Engineers Comments Regarding Surface Water Drainage

Application Reference:	WA/106/24/DOC	Reviewer Reference:	ADC/EXT2/D2134/68
Planning Officer:	Kathryn Welch	Date of Review:	24.02.2025
Site Name:	Land East of Tye Lane Walberton		
Application Description:	Approval of details reserved by condition imposed under reference WA/124/23/S73 relating to condition number 23(b) - SuDS System, and condition number 25(b) - SuDS Maintenance Manual.		
Assessment Number:	1 of 2

Topographical Survey

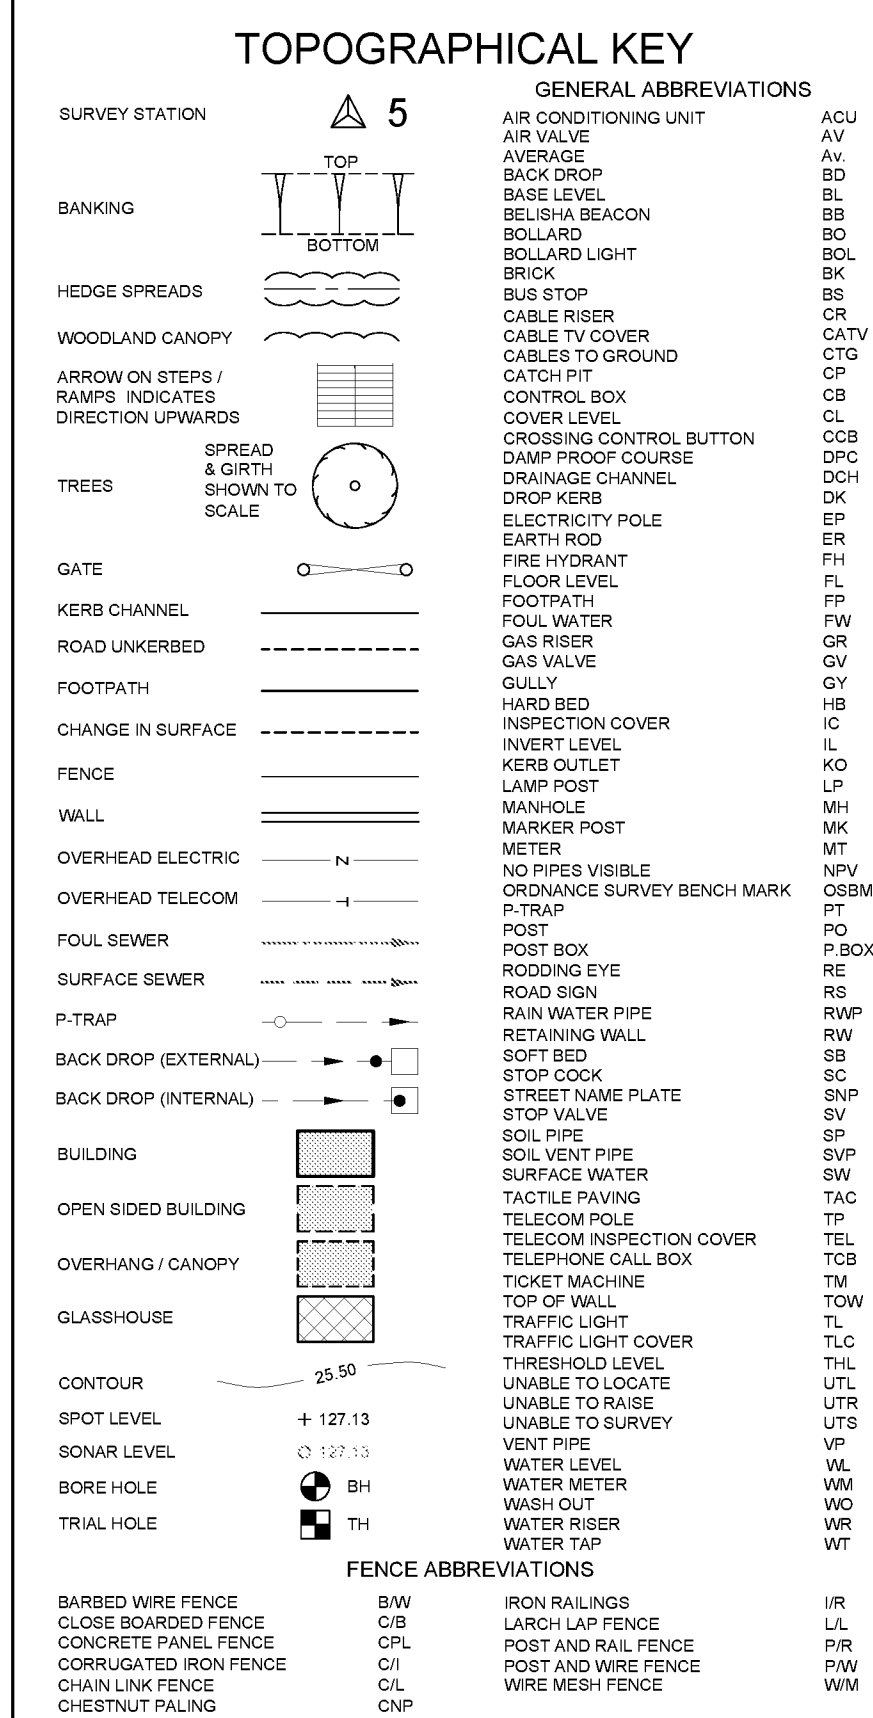
8.	The report should include an As Built survey to the requirements listed in ADC verification guidance note. It is recommended that the author reviews this list and arranges the revised report accordingly.	Appendix D provides an as-built topographical survey however this only captures the swales and basins for phase 1. Comprehensive evidence for phase 2 is required. Evidence must be provided to ascertain if the FFL's for plots, roads and how they compare to the SUDS permeable pavement and to ensure no increase in flood risk.	Added to appendix F

FFL Survey & Supplier Material Details

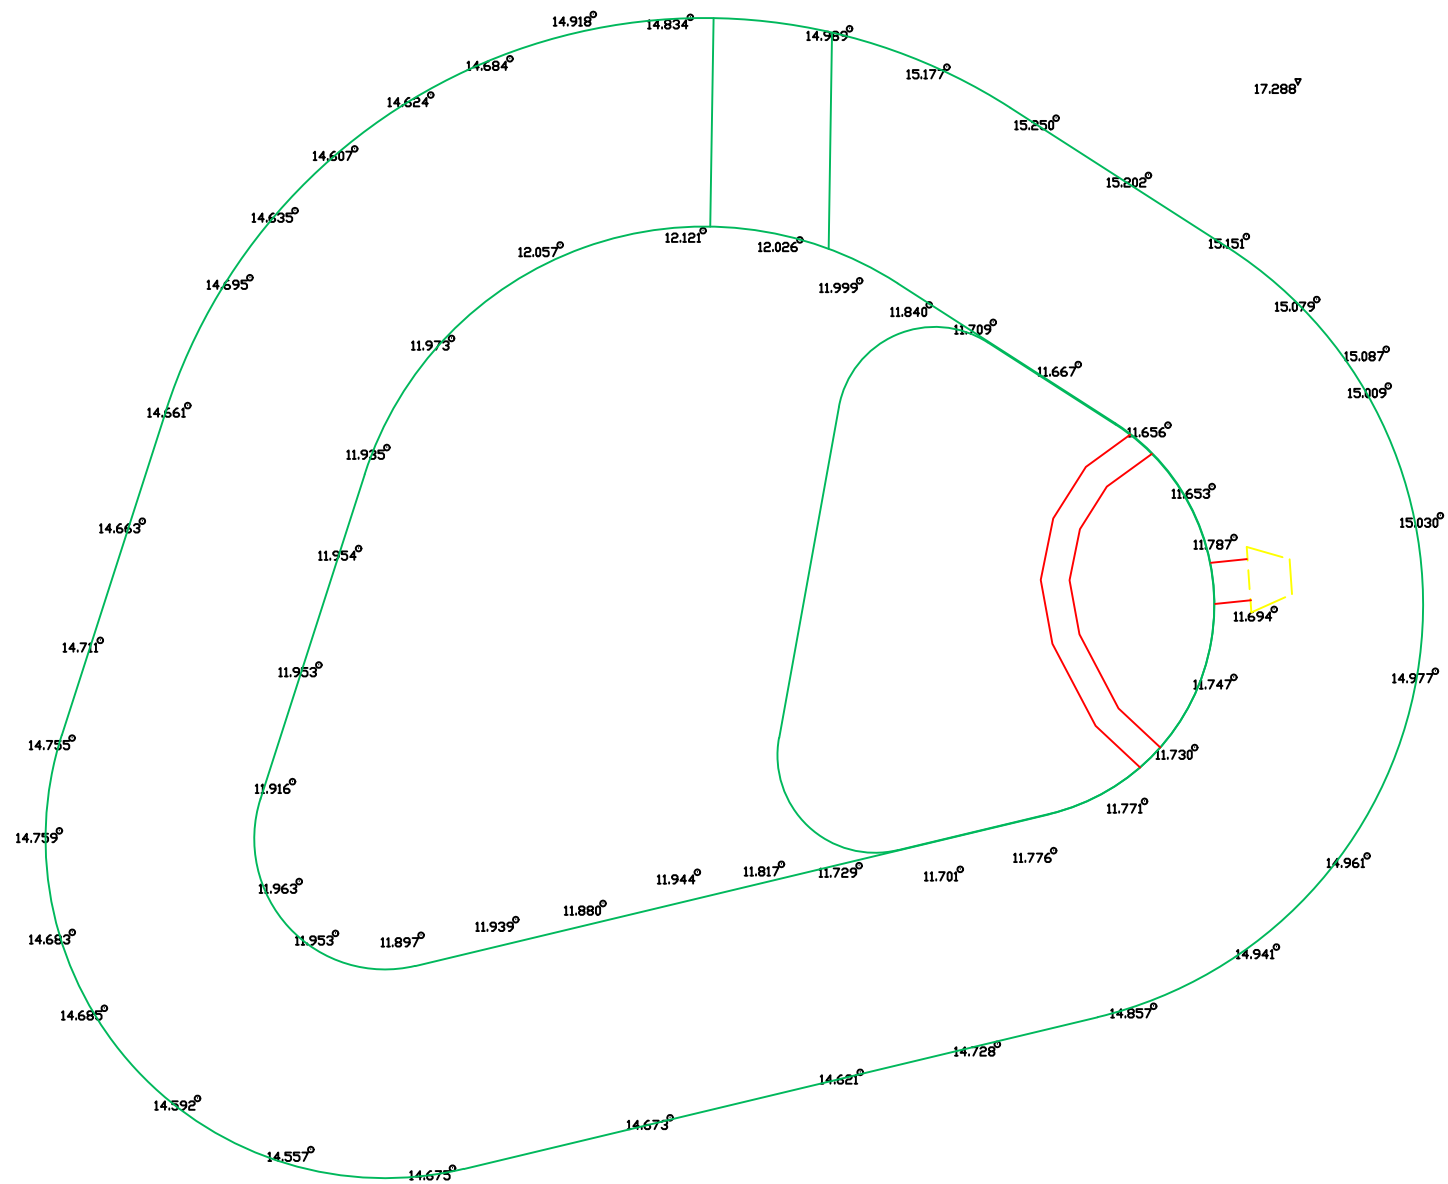
10.	The purchase information for the all SUDS components is required.	Comment outstanding.	Added to section 5.8 & appendix F		
11.	Evidence of permeable pavement installations must be provided to verify depths, etc.	Comment outstanding.	As per appendix F

12.	As constructed floor levels should also be verified/considered to ensure no increase in flood risk.	Comment outstanding.	As per appendix F		
13.	Page 24 photo evidence shows swale K/L to be incomplete.	The Barter Hill report includes numerous other photos which clearly show there are defects and issues on phase 1 so it is expected that defects will exist for phase 2 once summarised.	Comment updated
